February 24, 2016

Following recent discussions about Brick North, below is a summary of site work required for Brick North before Certificates of Occupancy can be issued. The attached color-shaded plans delineate site plan improvements for Brick North. Completion of this work will be considered towards fulfillment of the Level III Site Plan approval The Forefront at Thompson's Point Amendment Phase 1A, PEZ.2014-120 (approved December 4, 2014). This summary applies exclusively to requirements for Brick North. Full execution of the recently approved Level III Site Plan and Subdivision approval, PEZ.2015-133 & 2015-159 (approved January 21, 2106), is required for occupancy of Brick South.

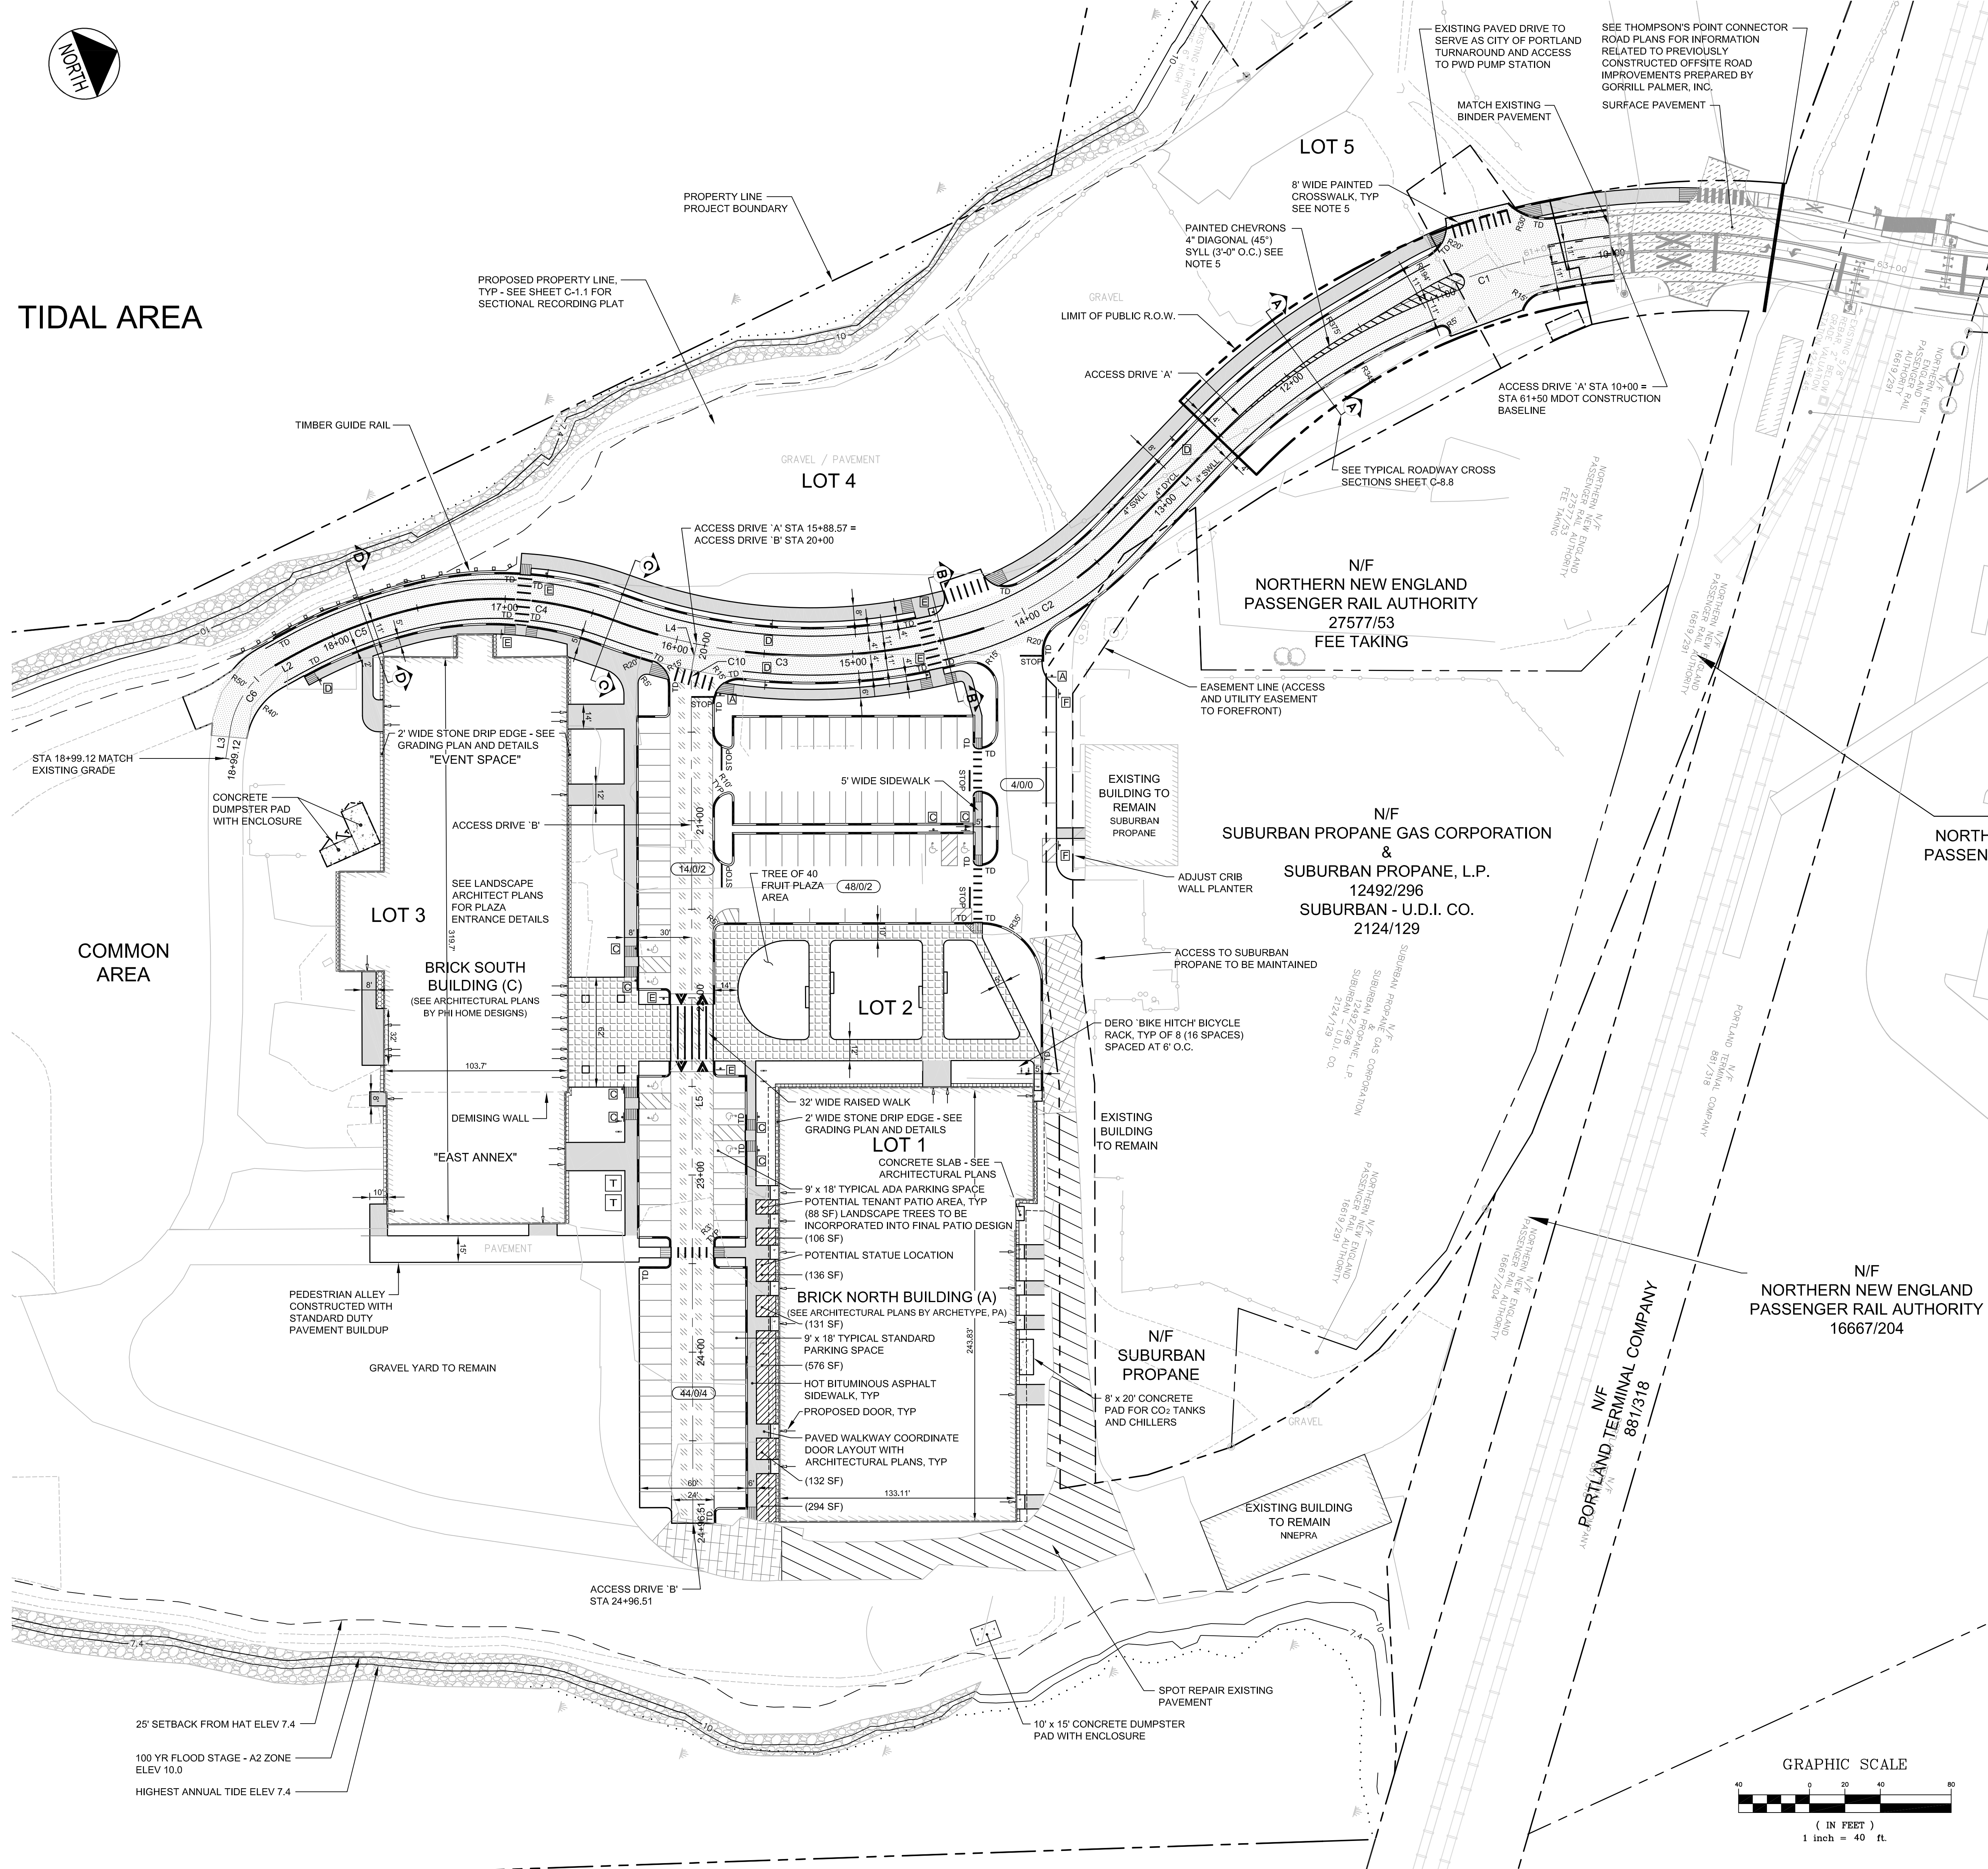
In regard to the areas called out with the notes: *Temporary Protected Designated Walkway* and *Improved Gravel Surface with Temporary Parking Demarcations* on the attached Sheet C-3.0, Site Layout Plan, final details shall be approved by the Planning Authority.

All work shown as shaded on the attached plans shall be completed before any Final Certificates of Occupancy will be issued for proposed new tenants. In the event that either plantings as shown on Sheet L-1.0, *Landscape Plan*, or the final paving course are not complete, yet all other requirements have been met, Temporary Certificates of Occupancy may be issued for new tenants through June 30<sup>th</sup>. The binder course should be appropriately striped to match the approved plans in the interim.
